## ISSUE SPECIFIC HEARINGS 4

### ERYC SUMMARY OF ORAL RESPONSES

Visualisation showing Proposed Onshore Converter Stations

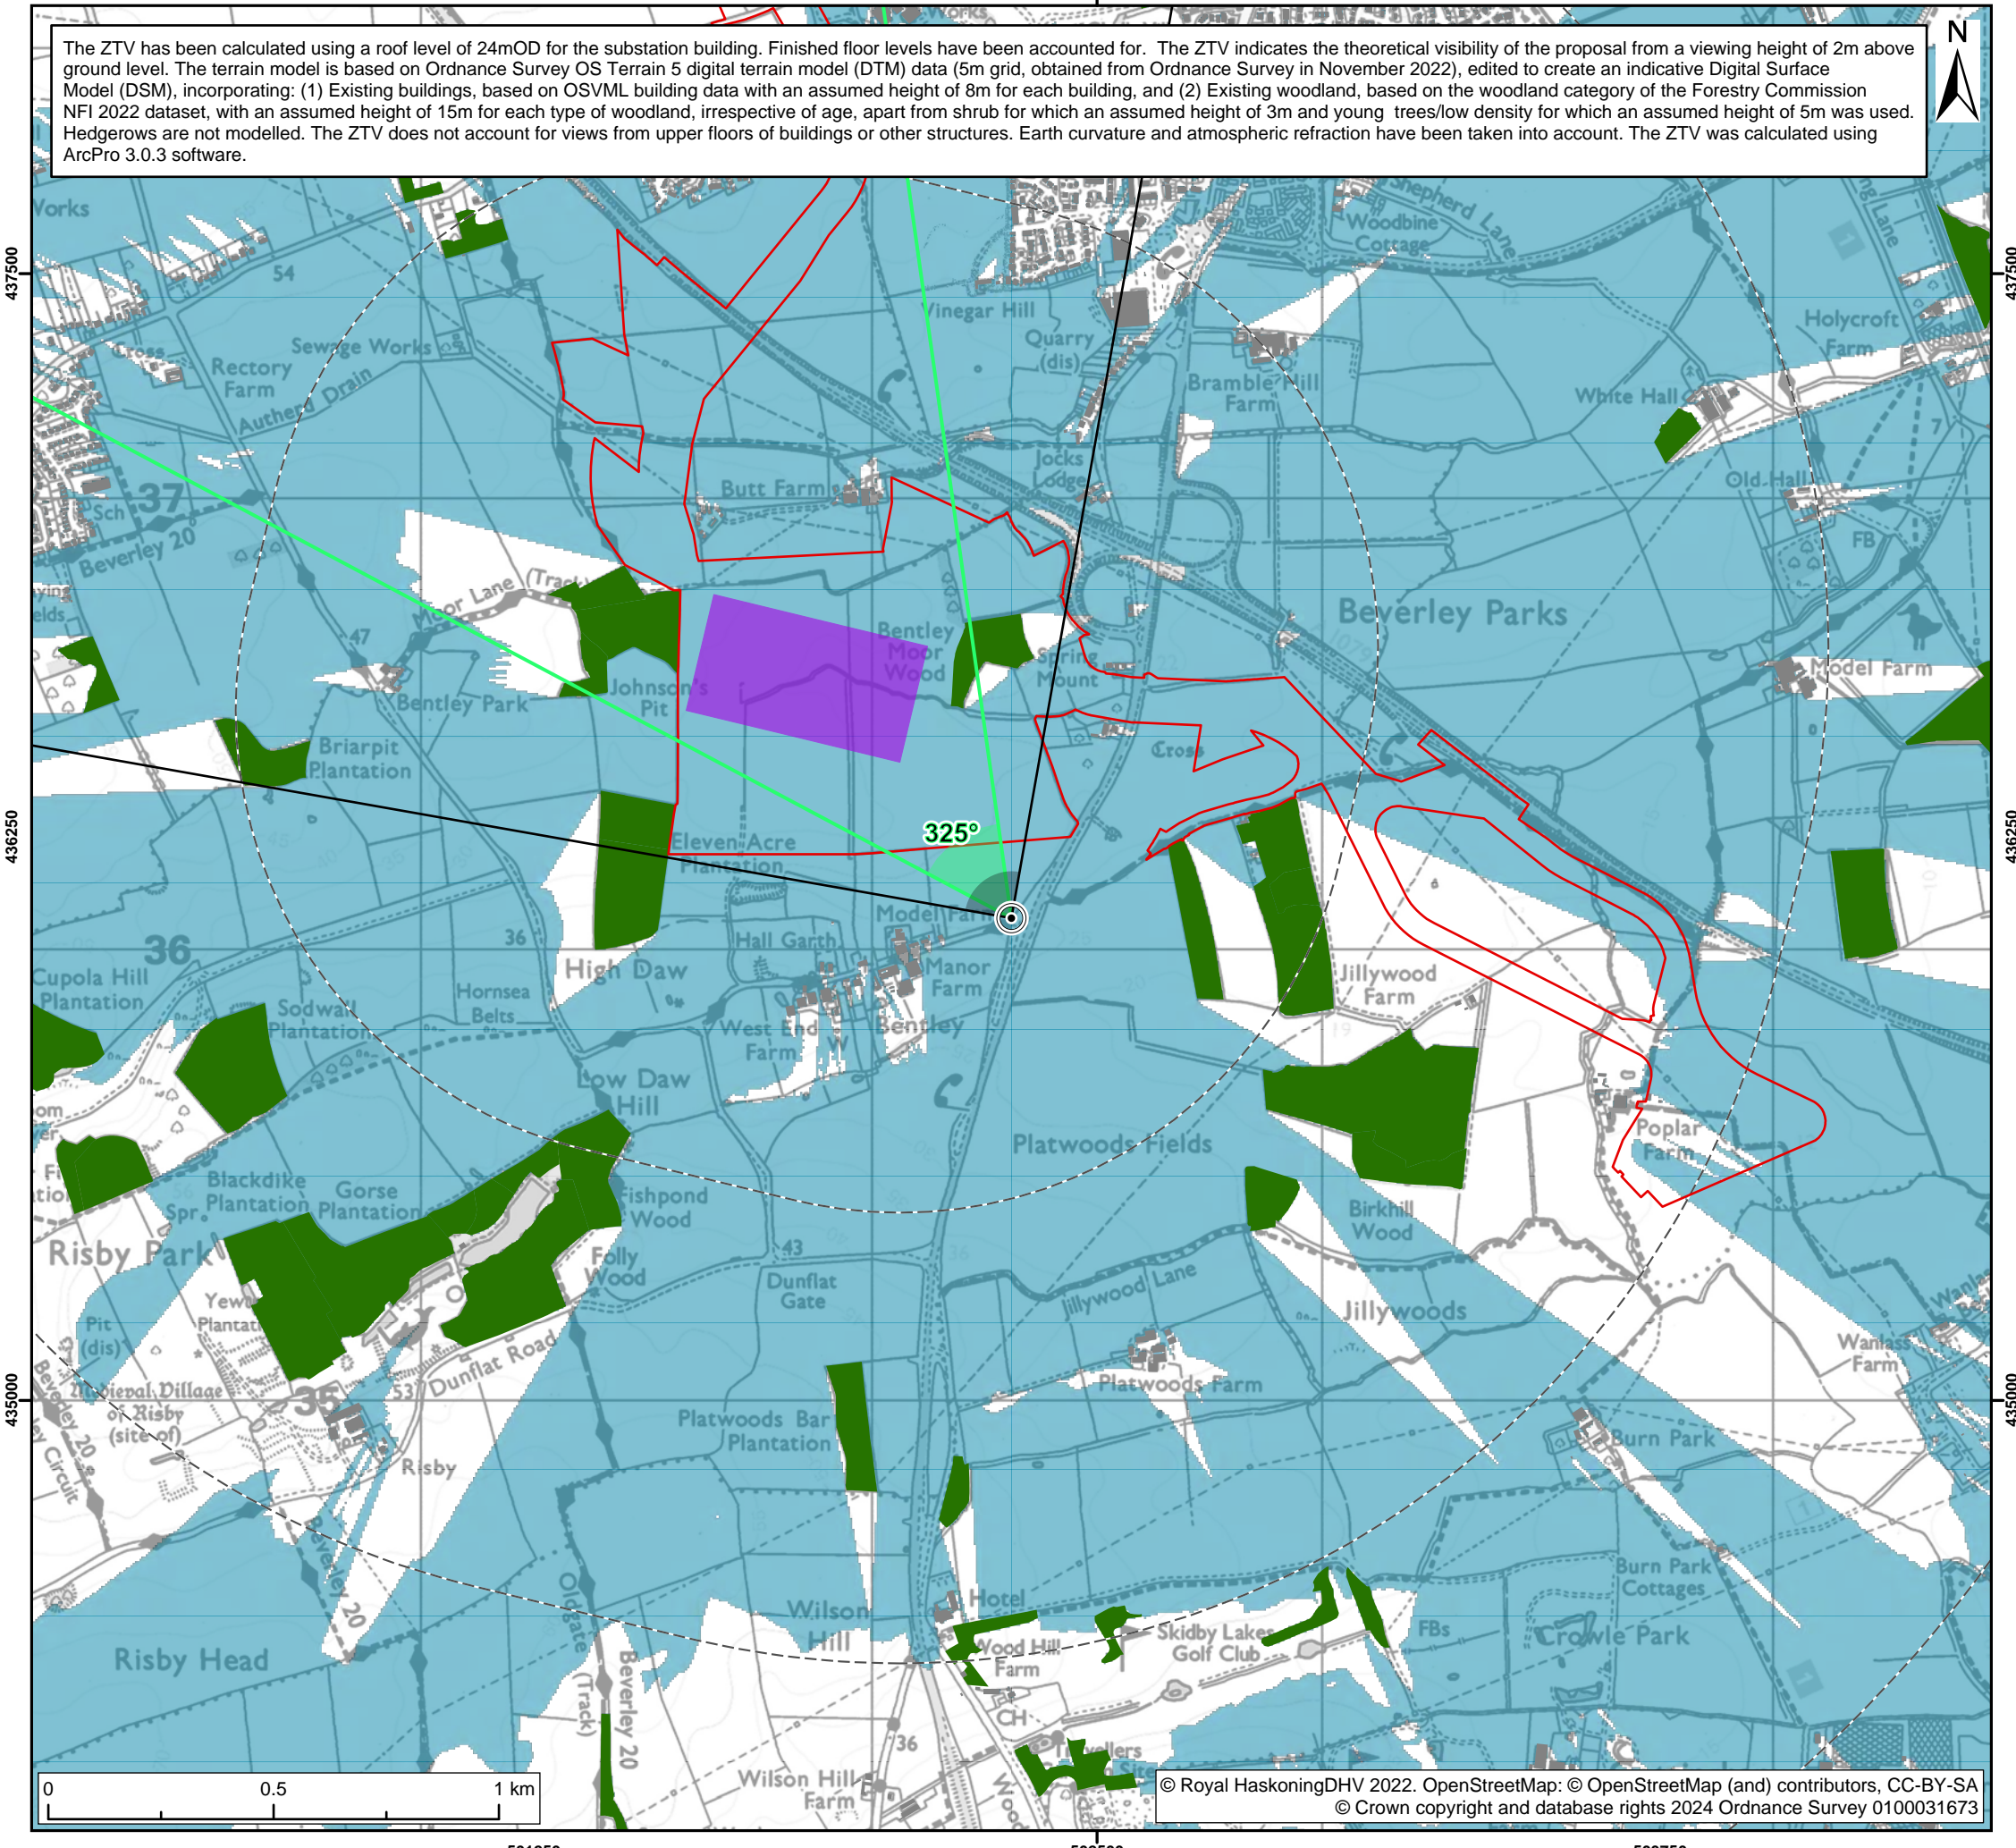
Agenda Item 3 Landscape character and visual amenity	
Question	ERYC Response
The ExA asked the applicants whether they felt viewpoint 1 represents an accurate visualisation of the likely effects from the most effected receptors, notably the residential and recreational uses of Butt Farm. Following the applicants comments ERYC views were requested.	Accept the applicants comments about normal practice being to select publicly accessible viewpoints and that this is the closest public viewpoint to Butt Farm. With regard to leaf cover this had also been raised in a recent meeting and it was noted that the plantation tapers towards the left of this view, which is the east of the view, and is considerably thicker towards the right, which is the west. Therefore in the area of the converter station we would have the greatest depth of mitigation planting. On that basis we accept that, even in a winter view, there would be quite effective mitigation planting for this view, which would thin out towards the left of the view. On that basis we would be content with the position that the applicant is taking on this view (BB)
